Charlotte Department of Transportation

Memorandum

Subject: Rezoning Petition 08-134: Located on the southeast corner of Selwyn Avenue and Queens Road West

ILLUSTRATIVE SITE PLANS

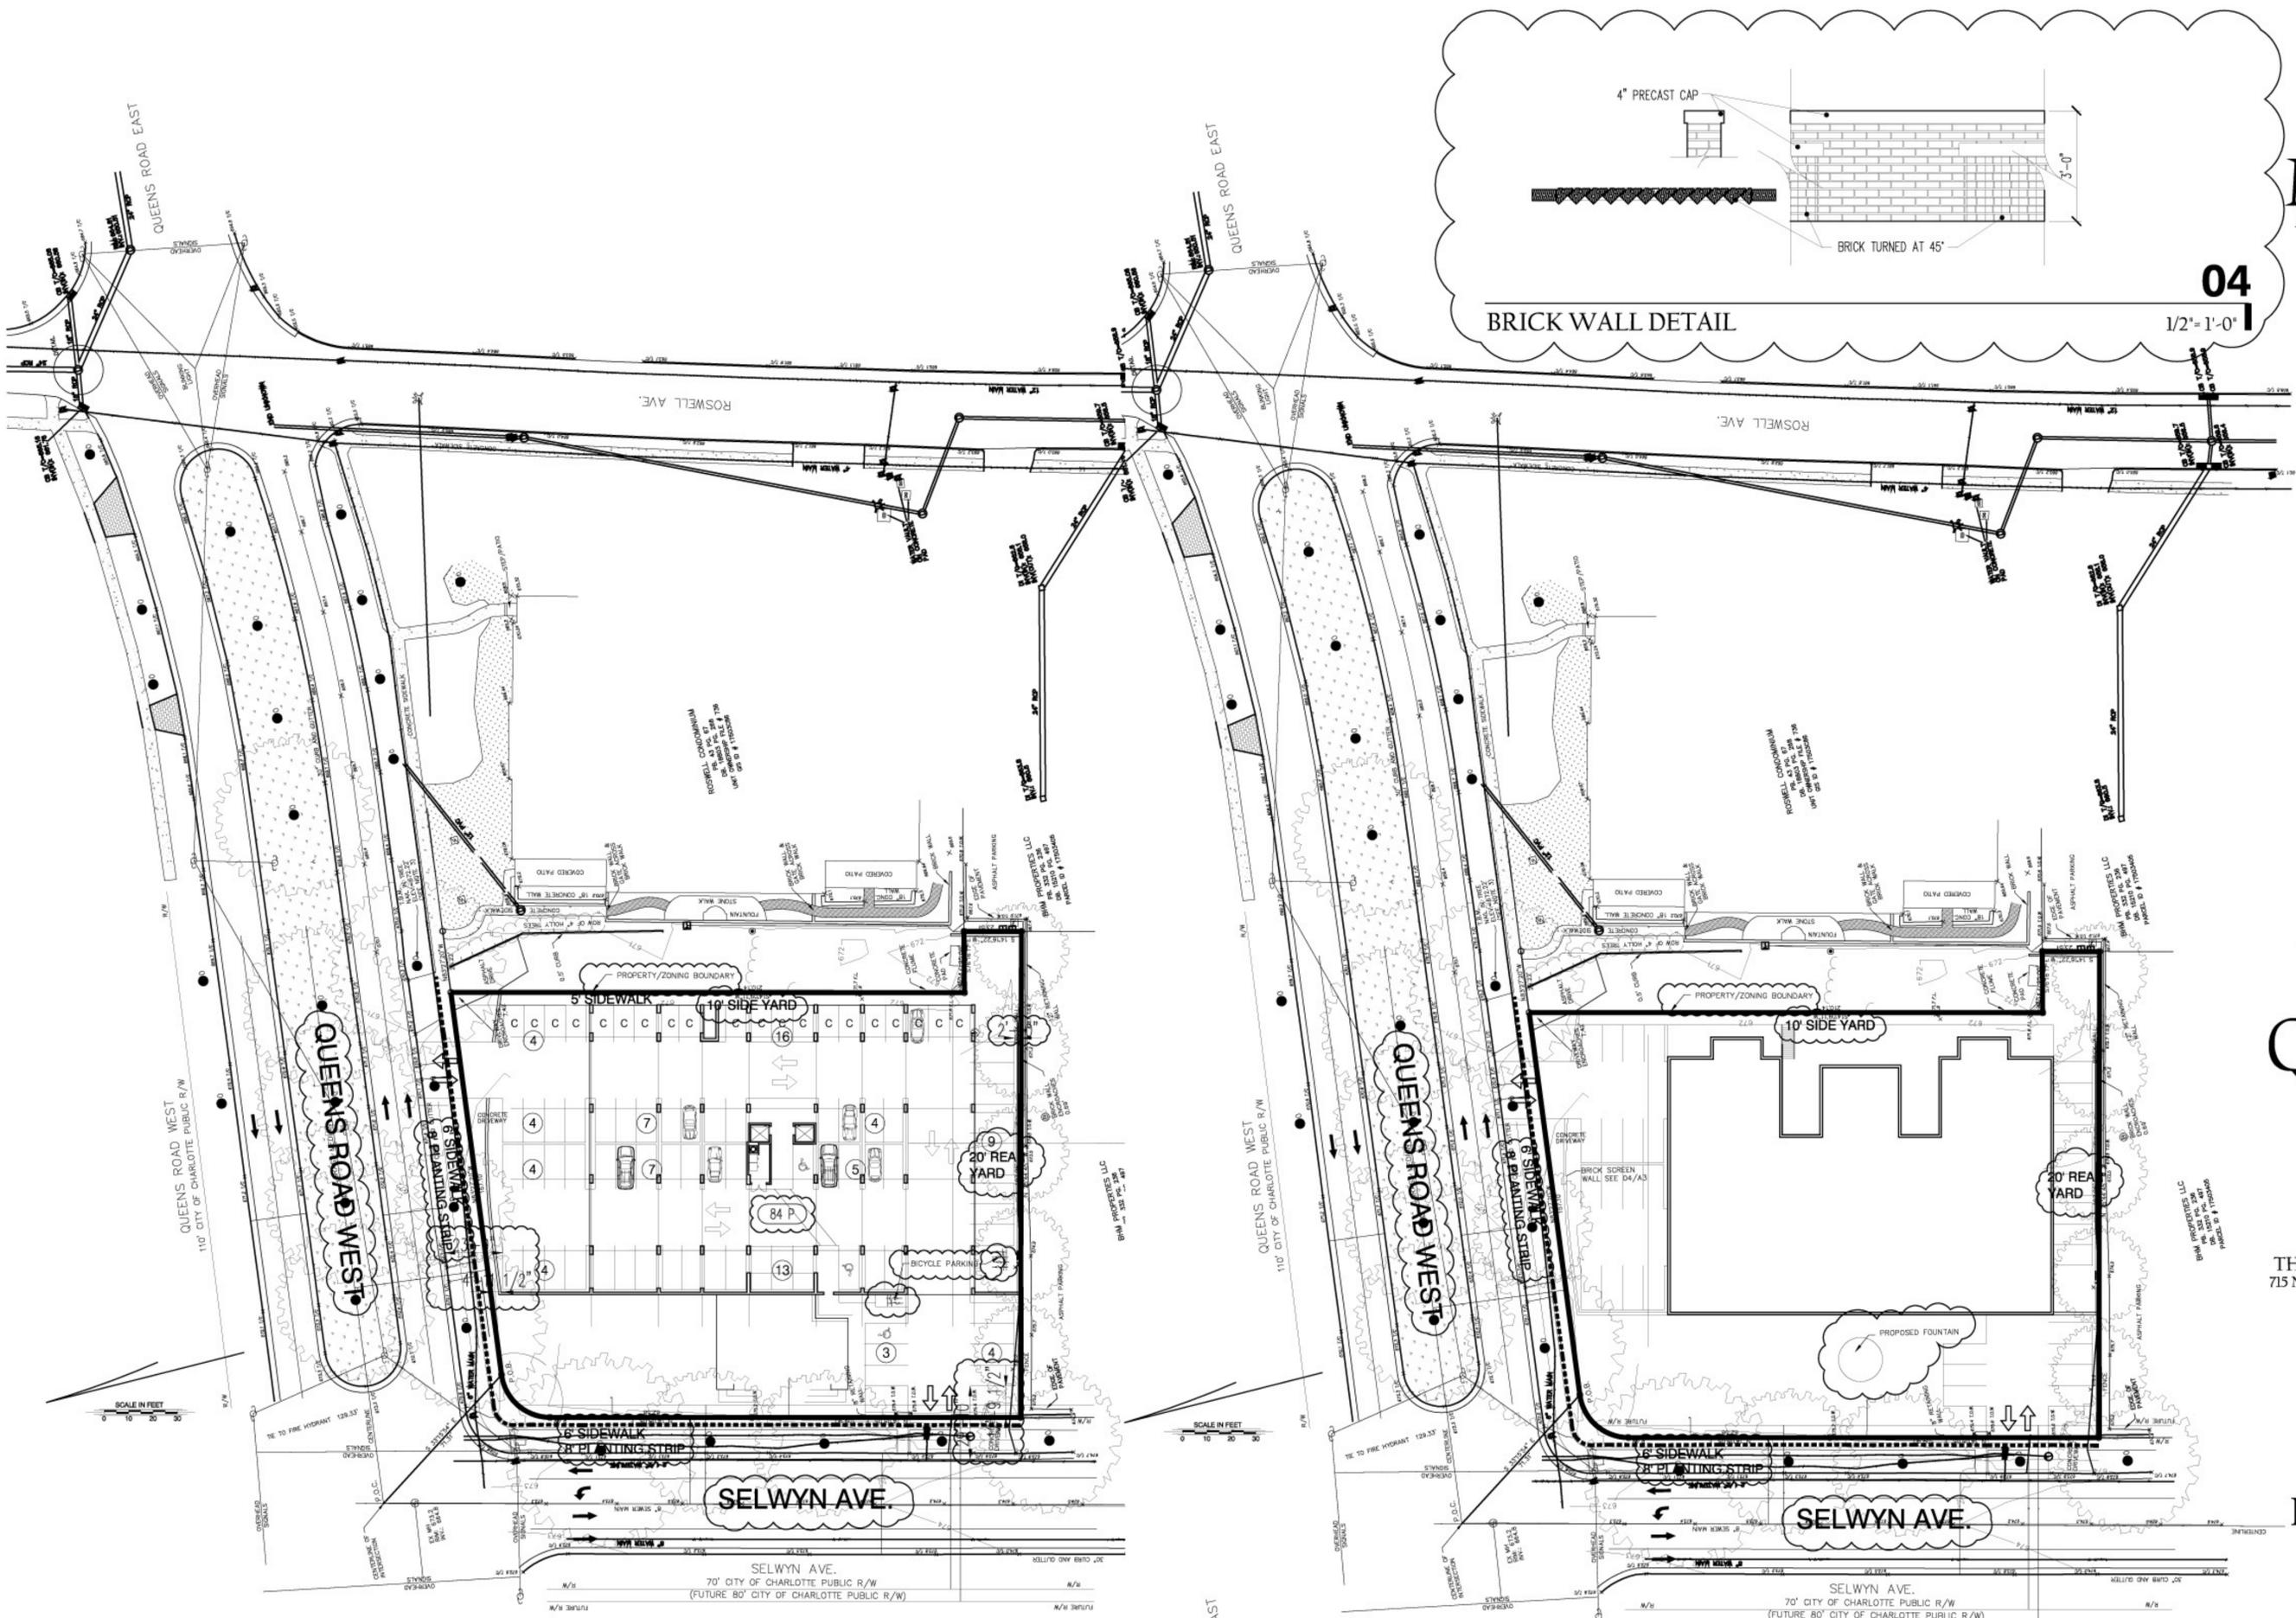
1. The developer needs to construct 6' minimum sidewalks (required by UR zoning) along Selwyn Avenue and Queens Road West, maintaining an 8' minimum planting strip back of future curb line. In the case of Queens Road West, the future curb line is the same as existing, meaning 8' planting strips along existing curb. However, in the case of Selwyn Avenue, the preferred cross-section would add 2.5' to the curb line (face). The new sidewalk needs to be constructed at a location that is 11' (8' planting strip + 3' to back of proposed curbline) from the back of the existing curb along Selwyn Avenue.

2. Selwyn Avenue is currently being evaluated for a road conversion via resurfacing that may provide two 4.5' bicycle lanes on paved gutters and a 3-lane cross-section of two 10' travel lanes and an 11' two-way left-turn lane (or 10' dedicated left-turn lane at intersections) and intermittent pedestrian refuge islands. To maximize the capacity of reduced lanes, the

petitioner needs to eliminate the driveway on Selwyn Avenue, restricting access to only Queens Road West.

3. Selwyn Avenue is a thoroughfare inside Route 4, requiring an additional 5' of right-of-way along Selwyn Avenue be dedicated to move the existing 70' right-of-way towards the adopted future width of 80'.
